WELWYN HATFIELD BOROUGH COUNCIL – ESTATE MANAGEMENT SCHEME
DELEGATED REPORT

APPLICATION No:	W6/2013/1580/EM
APPLICATION Site:	14 Fordwich Road, Welwyn Garden City

The applicant seeks for Estate Management Consent for the erection of a single storey rear extension with flat roof incorporating a rooflight. The proposal measures approximately 7.1m in width and 2.9m in depth. The flat roof would be constructed 2.7m above ground level and the rooflight would project 0.2m above the flat roof. The applicant also wishes to construct a porch serving the secondary front door, located in the alley way between the garage and main dwelling. The porch is proposed to be 0.9m wide by 2.1m in depth. The flat roof for the proposed porch would be to match that of the existing single storey flat roof.

Drawing No: 3089-P01 Revision: A

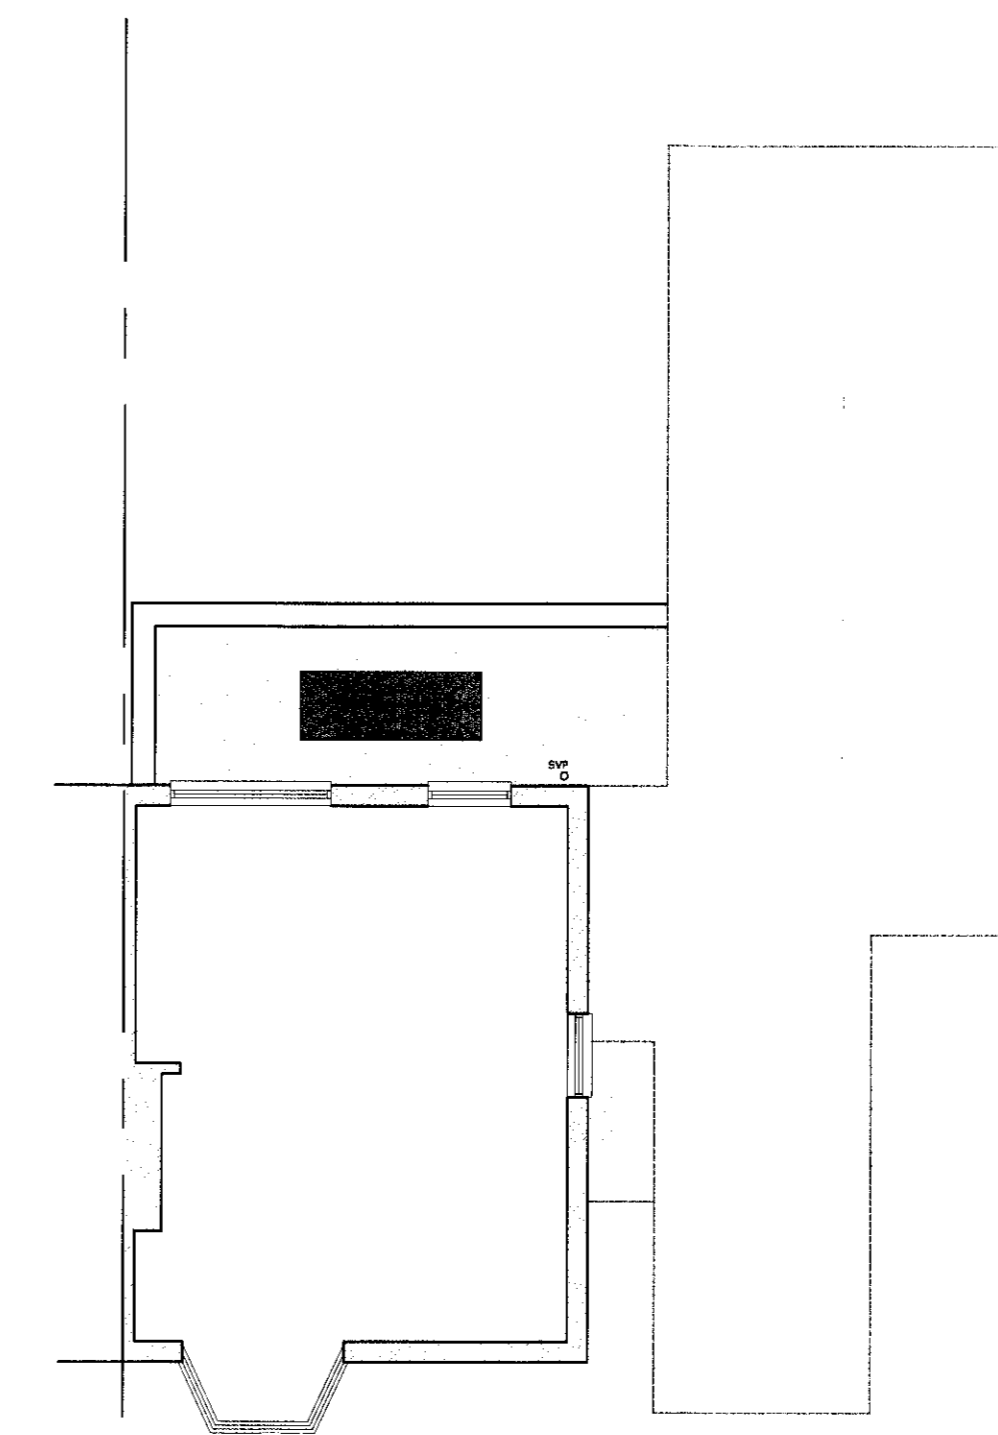
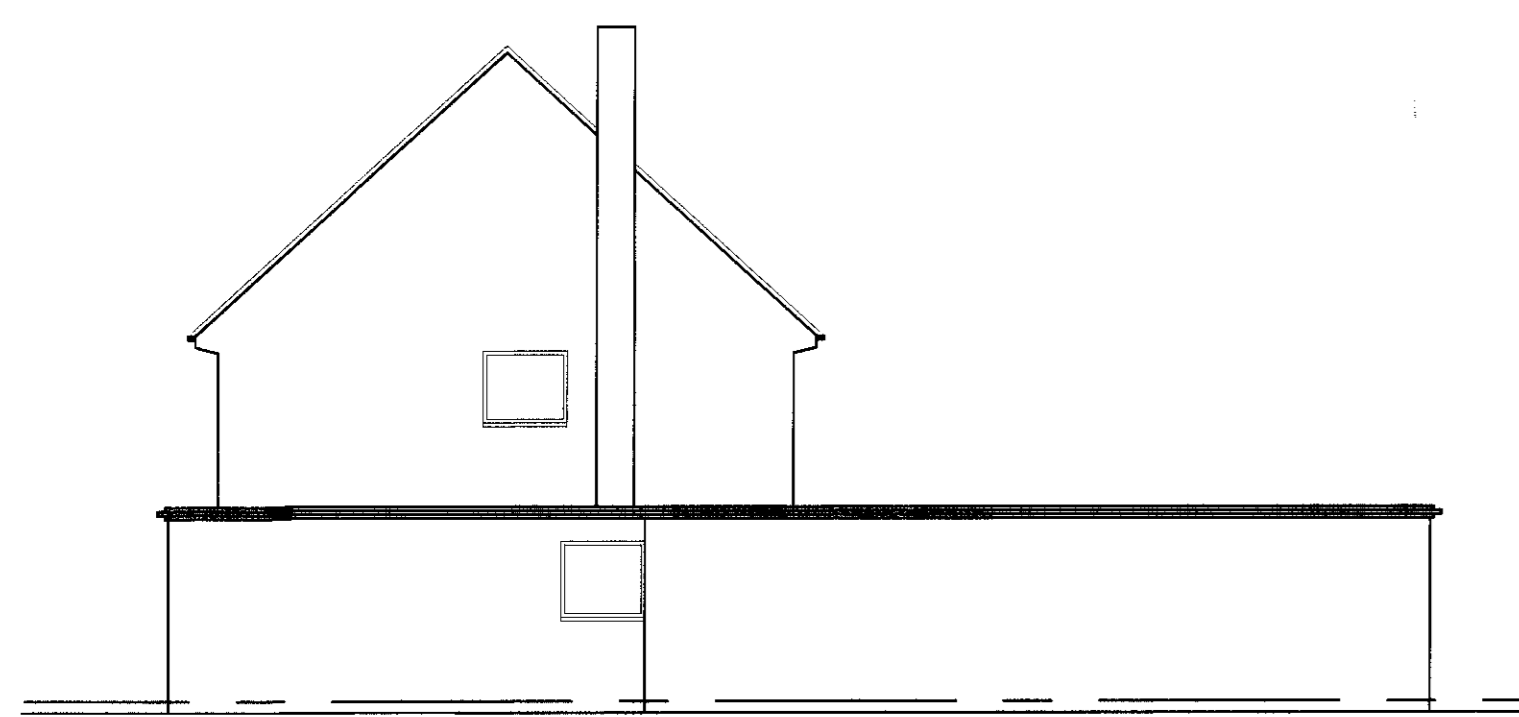
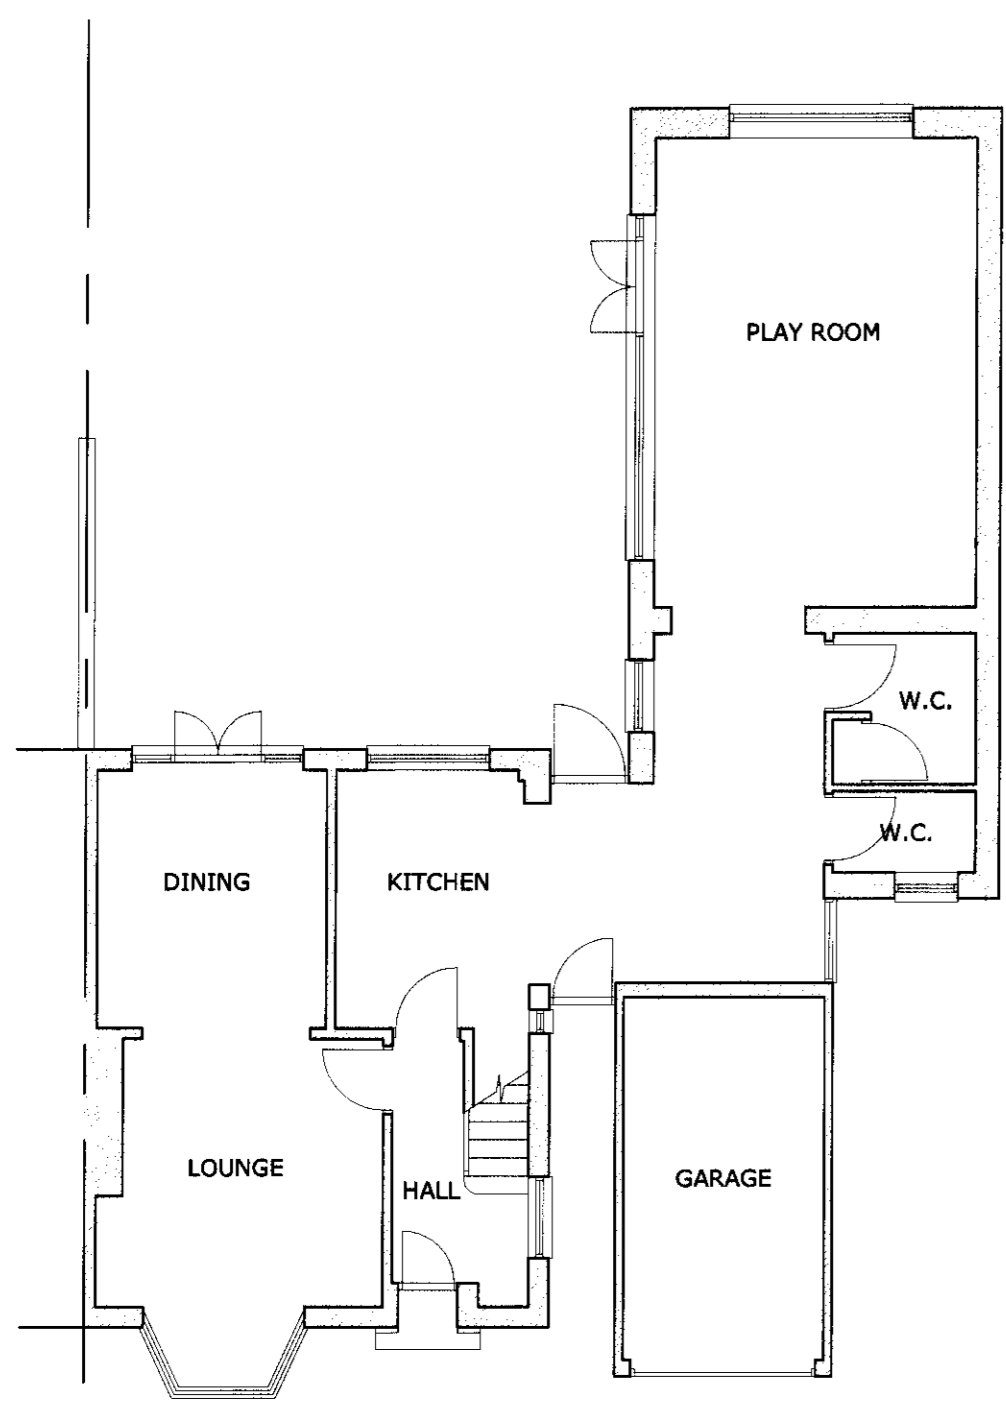
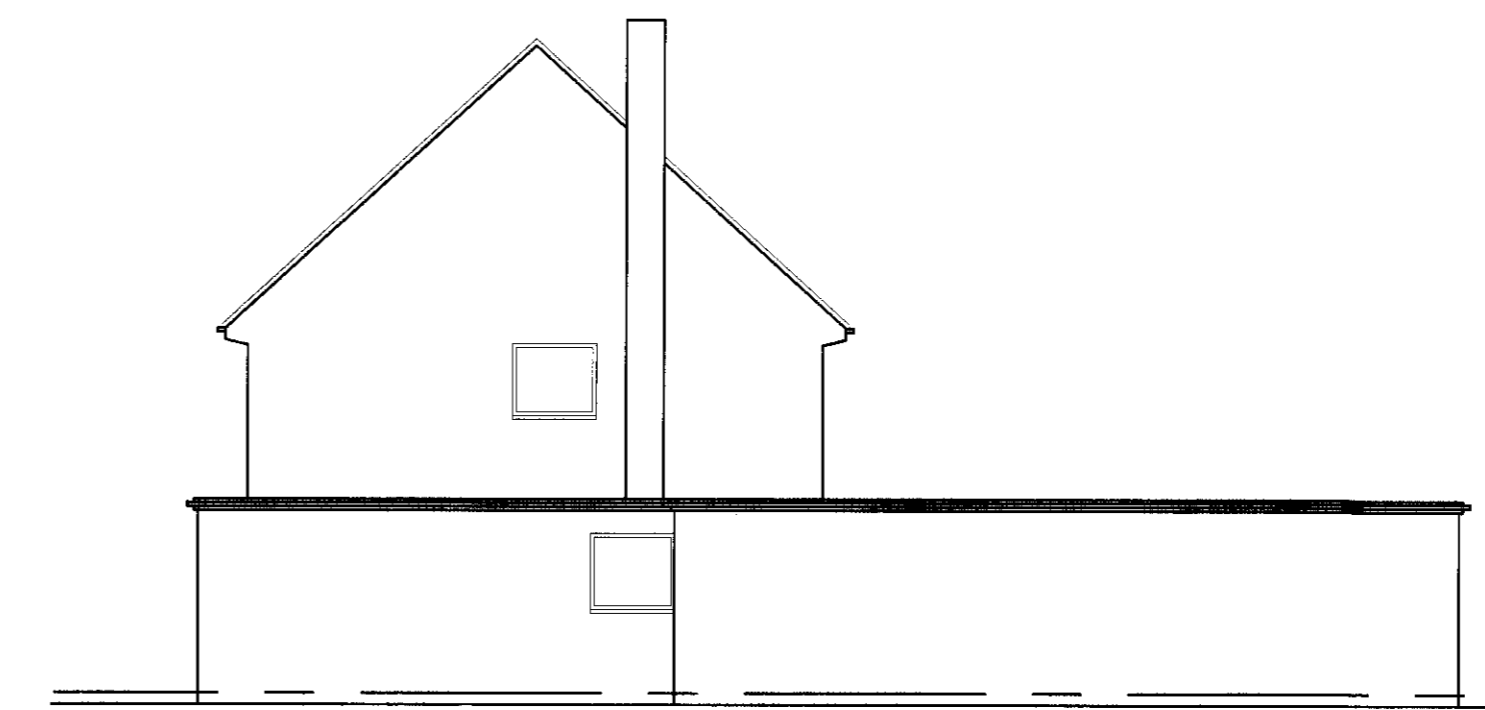
A single storey extension is proposed at the rear of the property at 14 Fordwich Road. The proposal includes a flat roof which would be in-keeping with the design of the existing dwelling as well as the being consistent with the architectural detailing of the Garden City. As the extension would have a flat roof and be single storey, it would not be visible from the public vantage point of Fordwich Road. This will retain the visual gap at first floor level between properties; preserving the unique architectural heritage of the location.

The proposed porch to the front elevation would match that of the adjoining dwelling at no.16. It is considered that the existing alleyway on the property between the garage and main dwelling is a feature which is commonplace in the area; it works as an architectural aesthetic break in the front wall. The porch would infill some of this alleyway, however it would not extend all the way to the front wall and so this distinctive appearance would be maintained.

The neighbouring property of no.16 Fordwich Road adjoins the applicant's property. The proposed extension will be built up to the boundary with no.16. However as the development is single storey and the land is level with the neighbour's property, there would be no overly dominant or overbearing appearance when viewed from the neighbour's property. In addition, the resultant property at no.16 would not impact on the level of day/sun/sky light afforded to the adjoining neighbours thanks to the proposed orientation and scale. Accordingly the proposal would not be detrimental to the residential amenity of adjoining occupiers.

- 7. EM03 The brickwork, rooftile, bonding, mortar and architectural detailing (including soffits, eaves, external pipe work and guttering) of the approved extension/alterations shall match that used in the existing dwelling, unless otherwise agreed in writing by the Council.
